Department of Planning, Industry & Environment
GPO Box 39
Sydney NSW 2001

Application No: SSD-10831778

Re: Randwick City Council submission on the State Significant Development SSD-10831778 – Sydney Children’s Hospital Stage 1 and Children’s Comprehensive Campus Centre (SSD-10831778)

SITE PLAN - SOLAR STUDY
SHEET 03

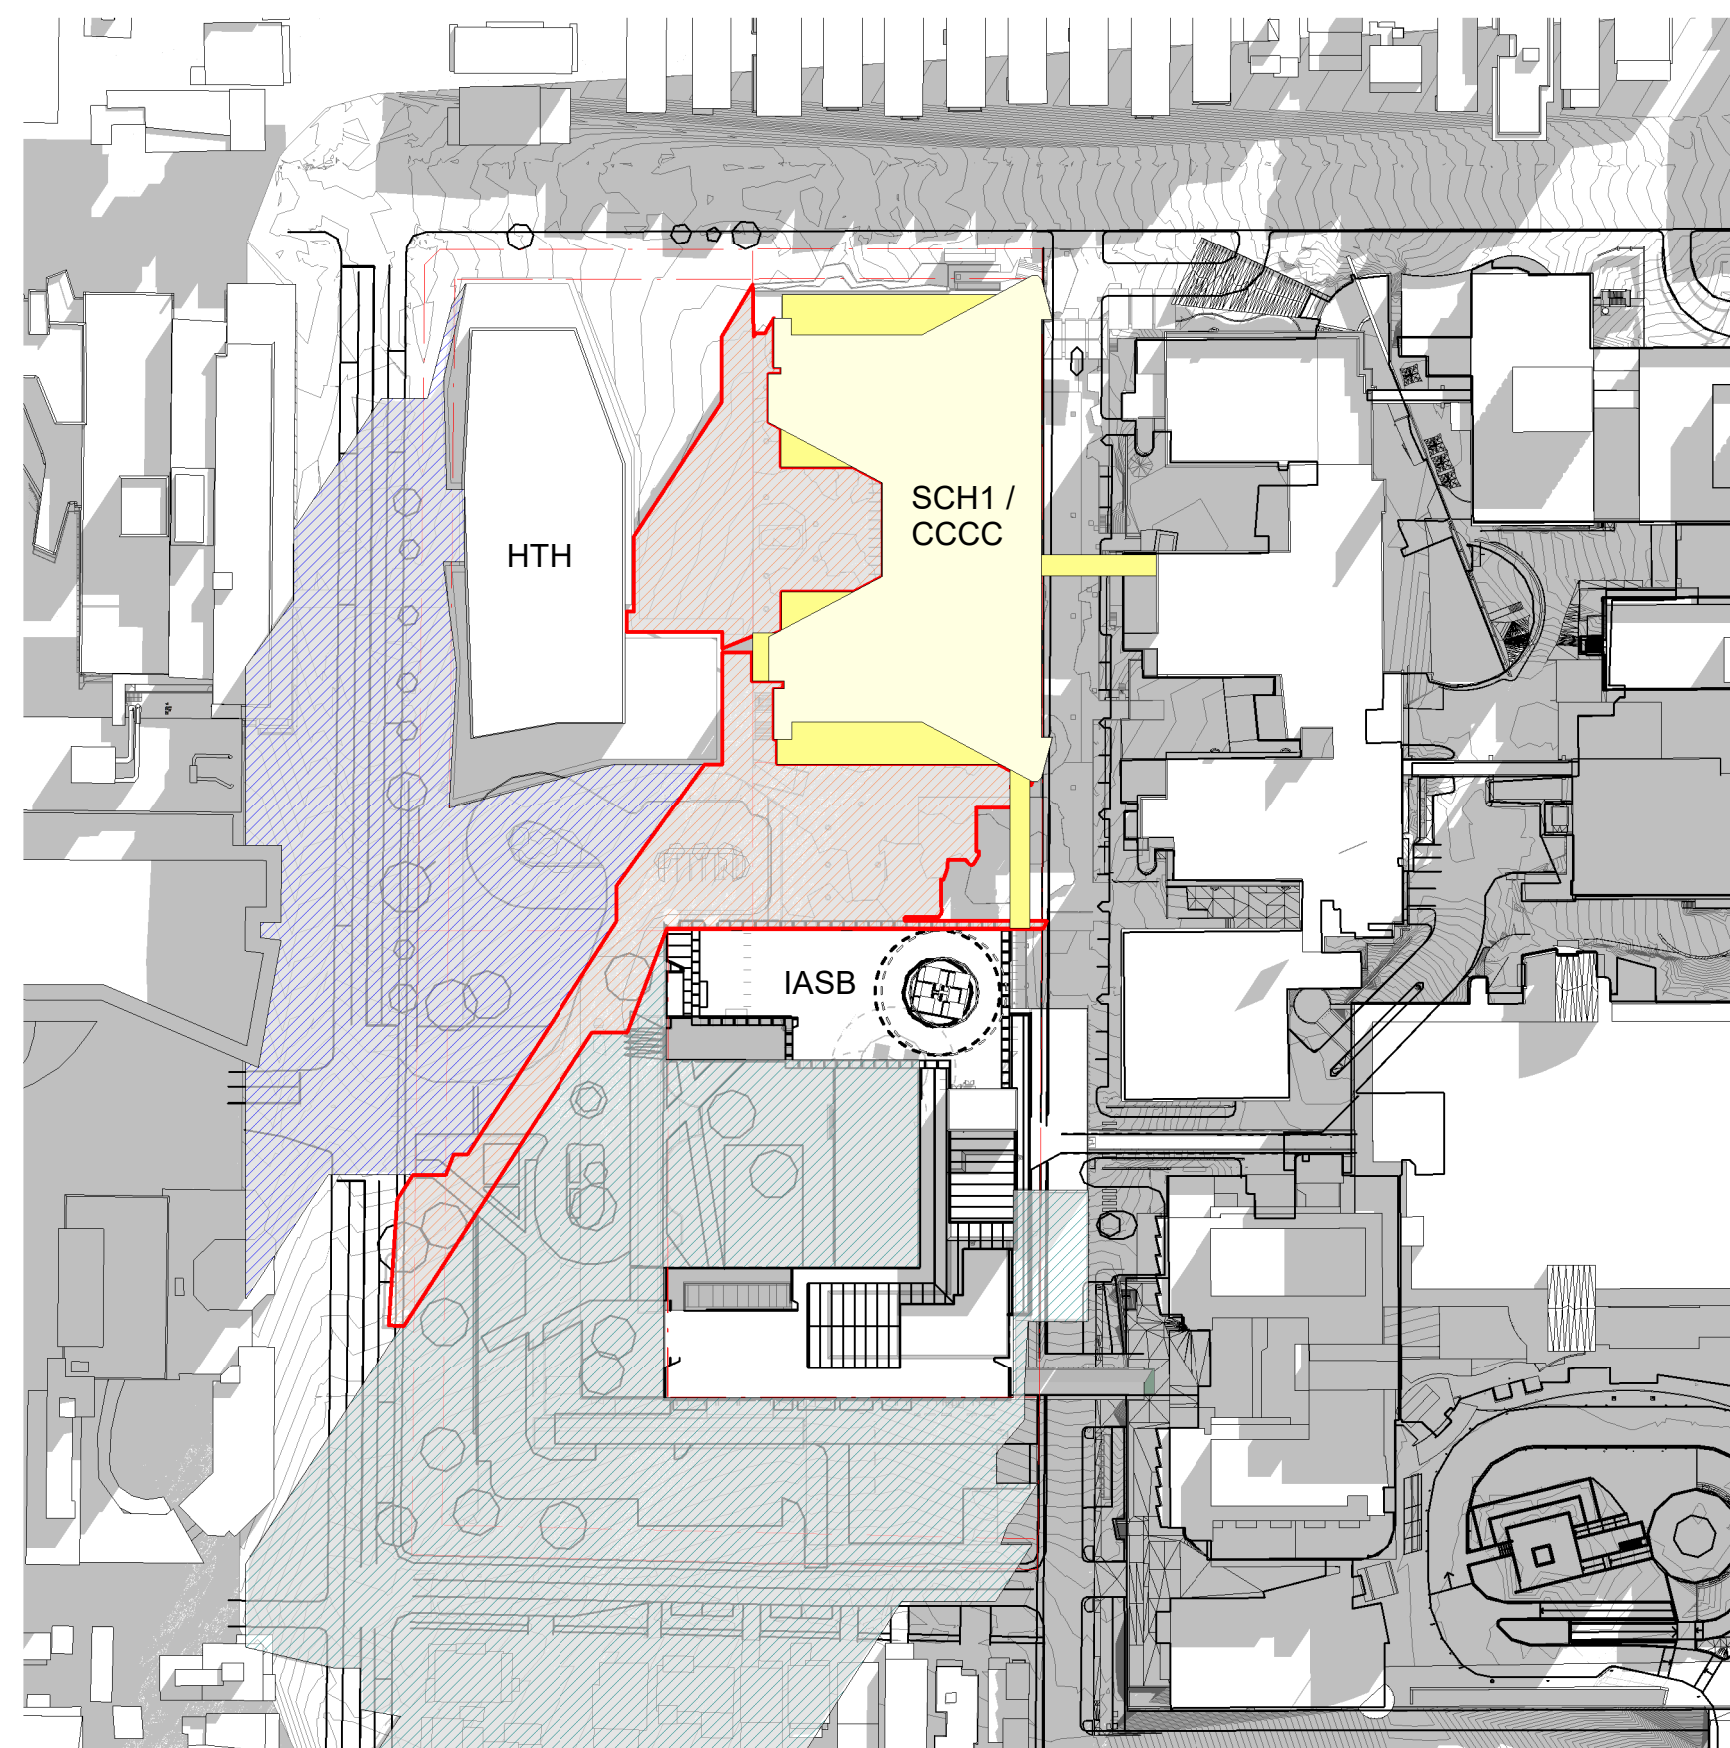
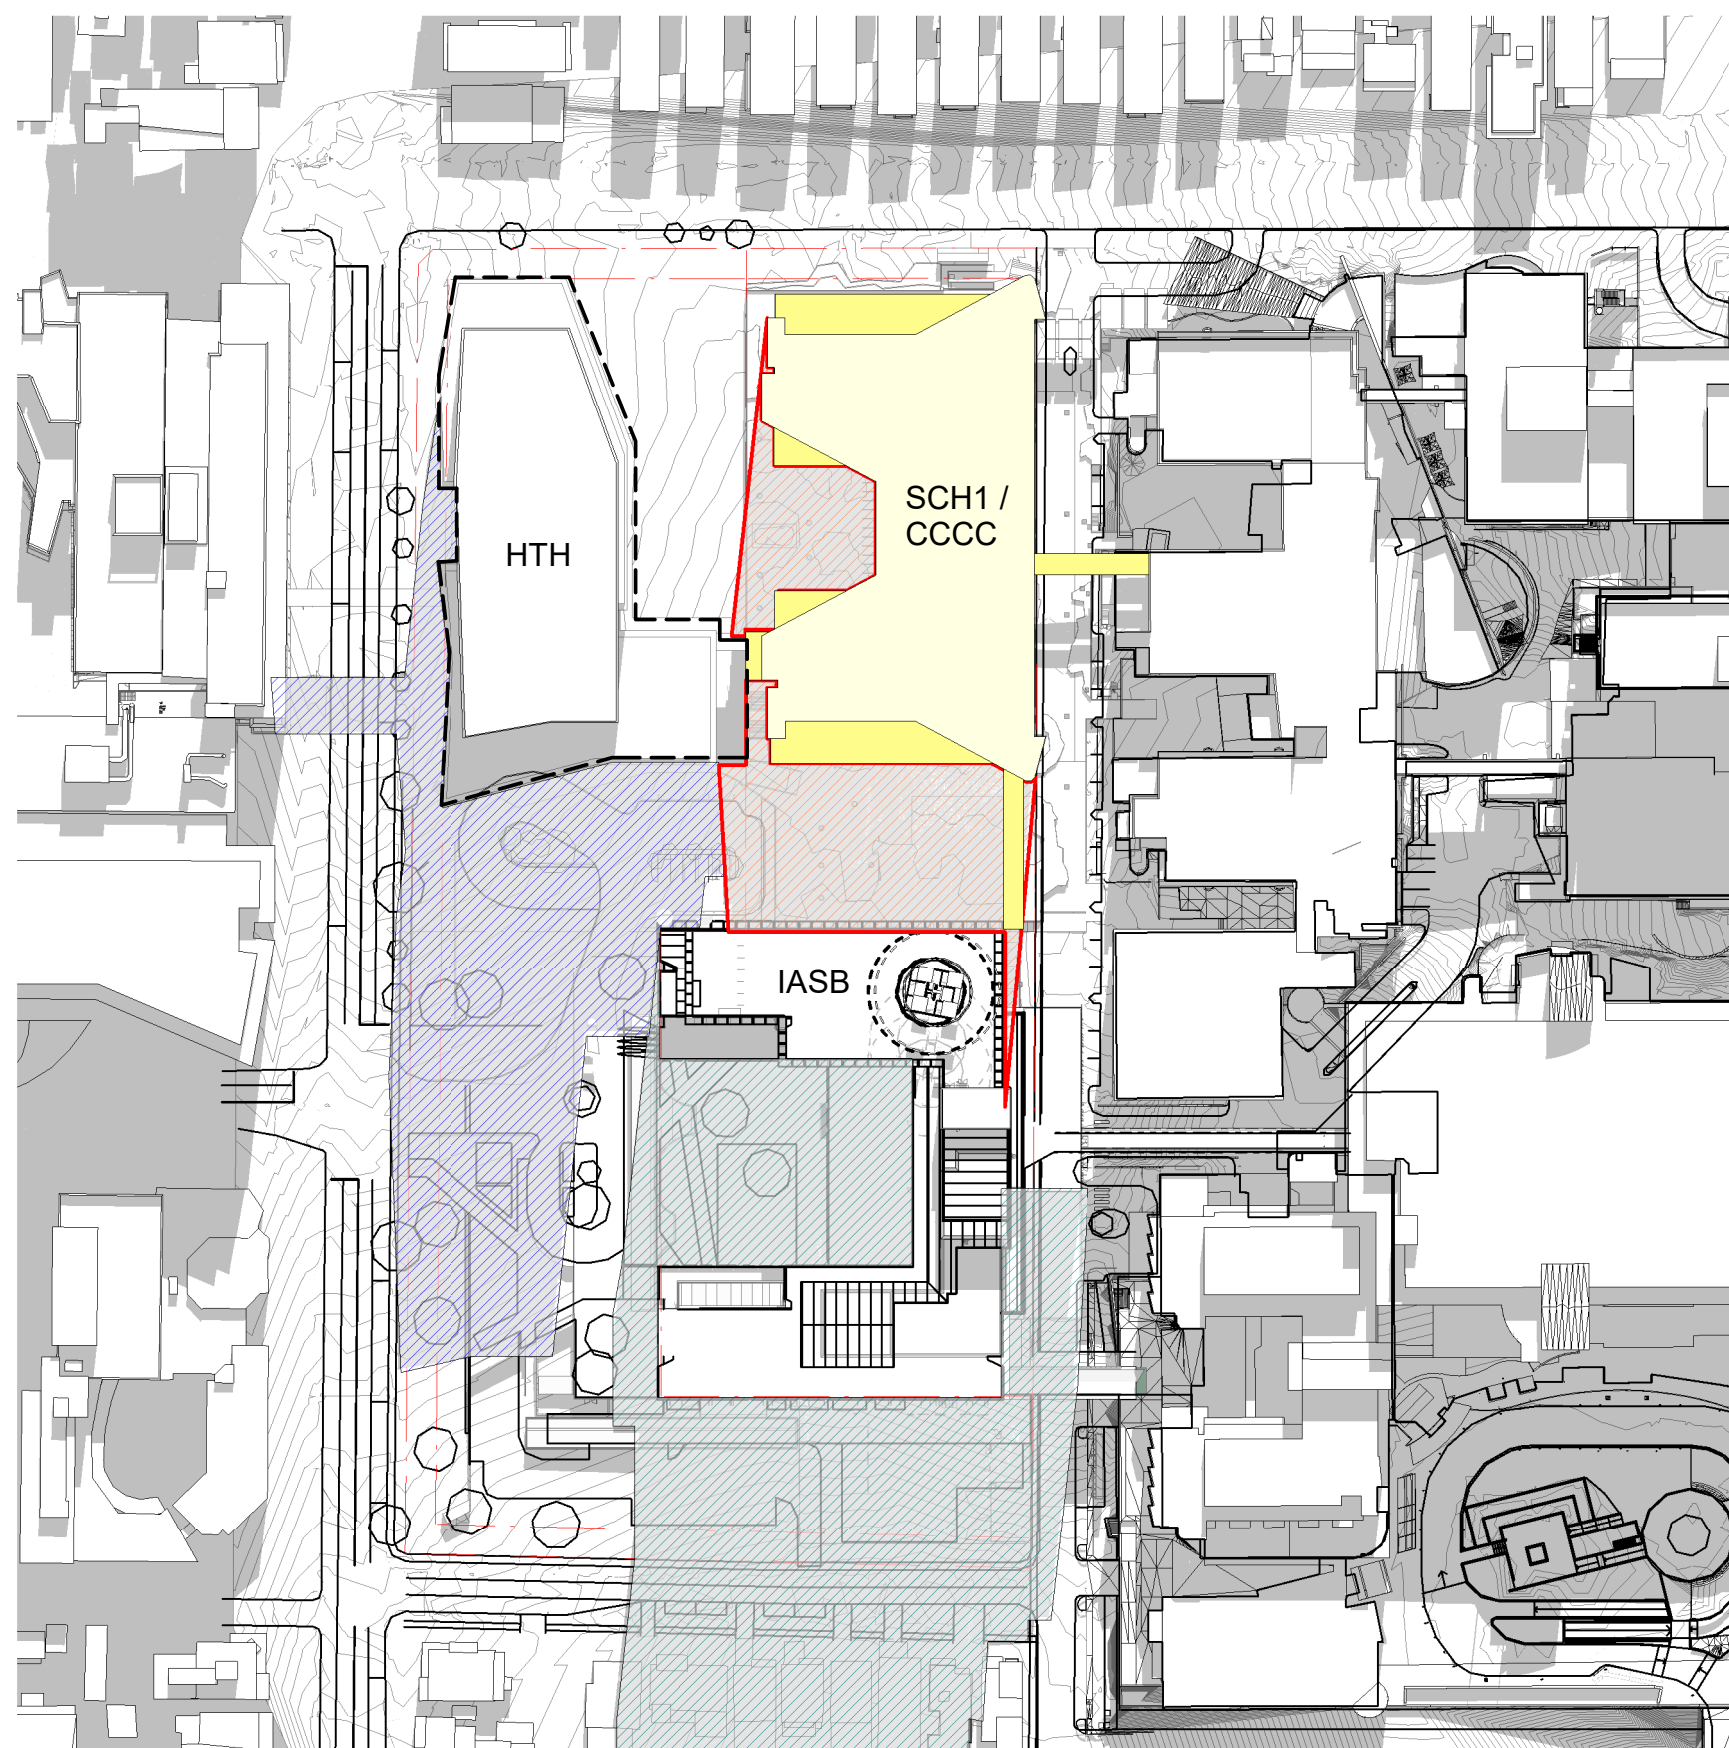
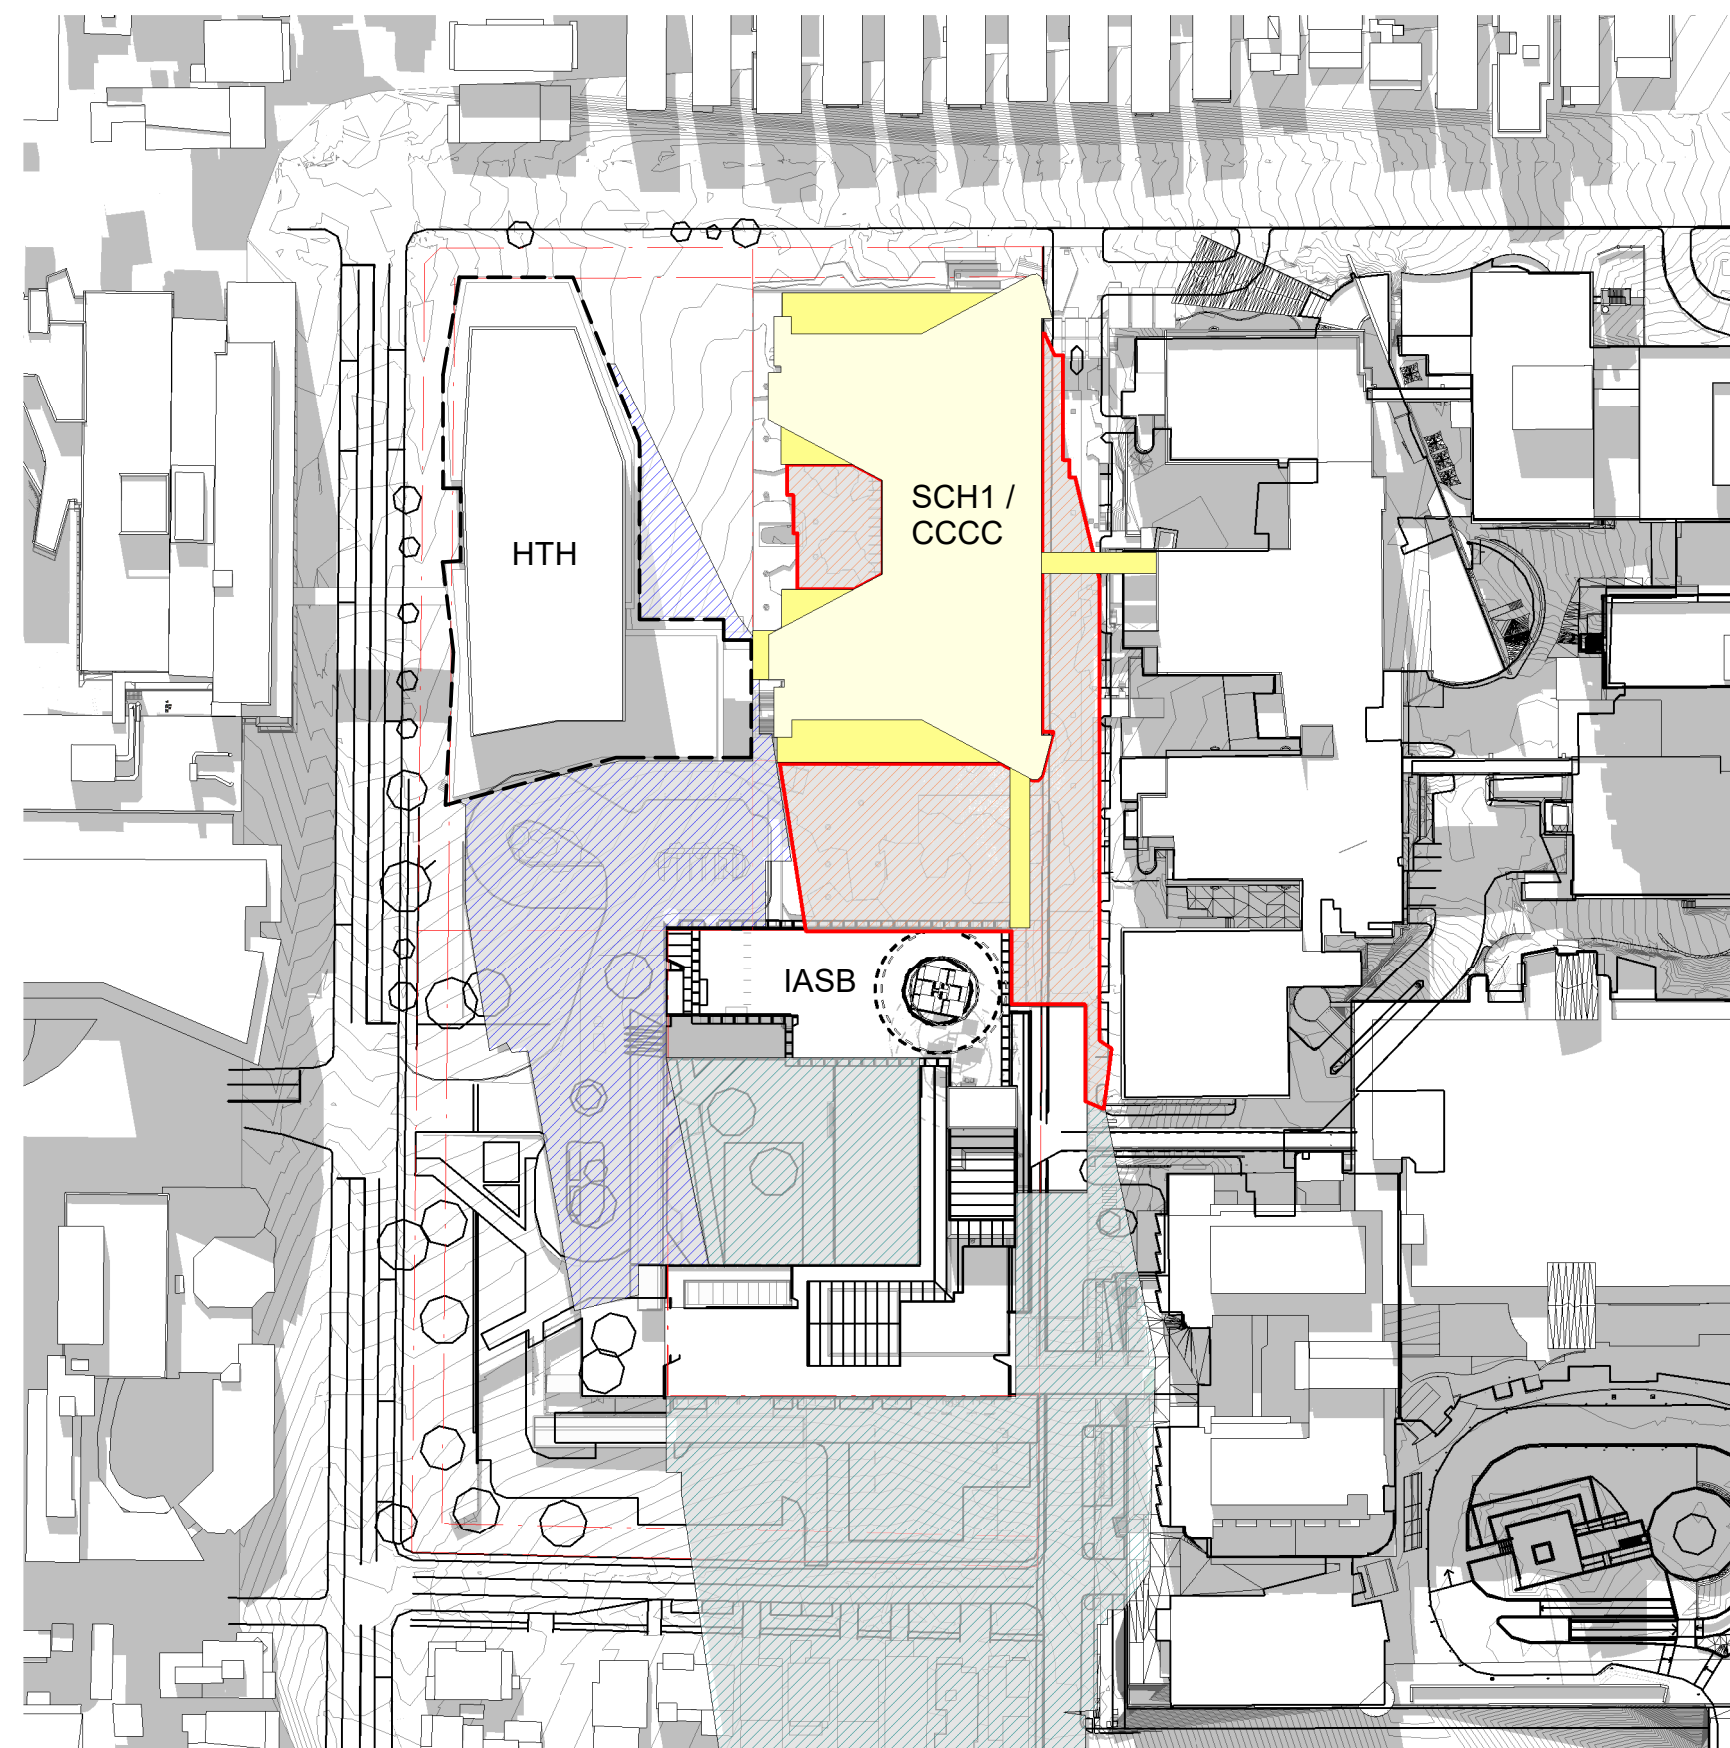
30. Shadow studies should be provided at hourly intervals for the winter solstice to assess solar access to the key public domain areas such as the plaza and children's play area.
